From: [Stuart Dixon](#)
To: [Planning](#)
Subject: FW: Planning Application Consultation 21/00775/FUL
Date: 04 June 2021 14:59:55

Refuse Collection for new builds as per past comments in regards to bin positioning (Nearest point to collection vehicle), bin collection points (at end of private drives/service roads), ability for up to a 32 tonne RCV to preferably drive in/out of areas or enough room to reverse into areas.

TITLE: PROPOSED SITE LAYOUT

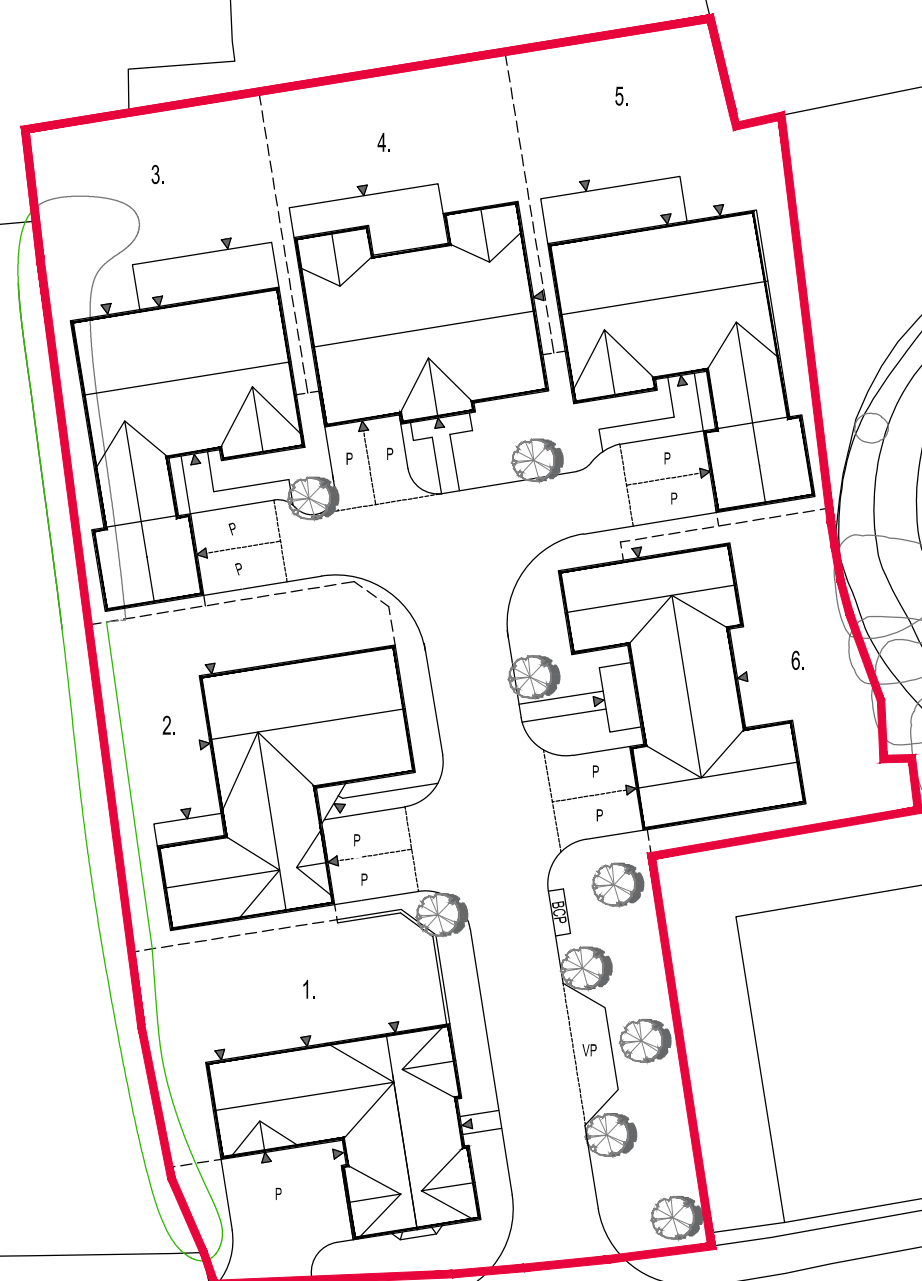
Storage areas should be at least accommodate up to potentially 3 x 240 Wheeled bins (Green/General Waste, Blue/Re-cycling, Brown/Garden Waste-Optional) with a view depending on future Government Legislation for Extra bins or Boxes.
